From: Fiona Fitzgerald <Fiona.Fitzgerald@arun.gov.uk>
Sent: 02 April 2020 16:58
To: Planning.Responses <Planning.Responses@arun.gov.uk>
Cc: Louise Crane <Louise.Crane@arun.gov.uk>
Subject: BR/315/19/PL

PROPOSED SECTION A-A

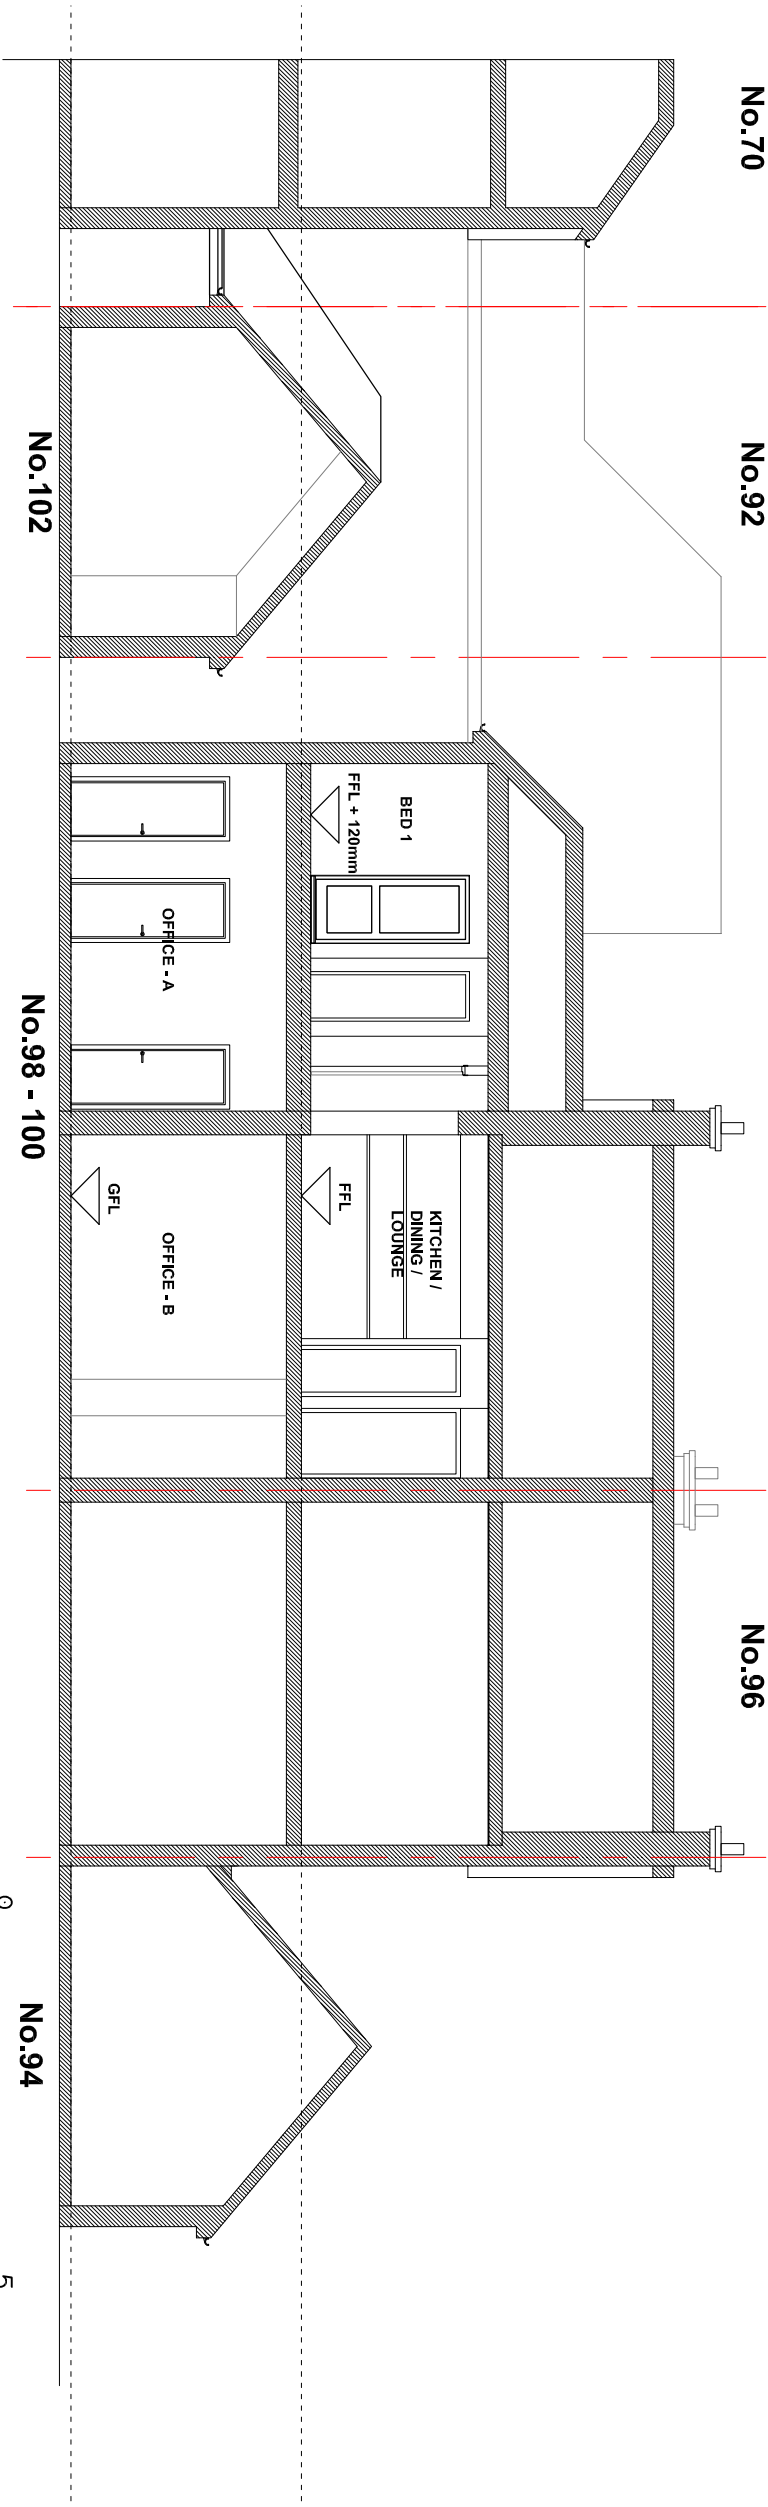
The sound insulation of the floor / ceiling between the ground and first floor shall achieve a minimum airborne sound insulation value of 50 dB ($D_{nT,w} + C_w$). Before the residential unit is occupied, a test shall be undertaken by a competent acoustician and submitted to the Local Planning Authority to demonstrate compliance with this level.
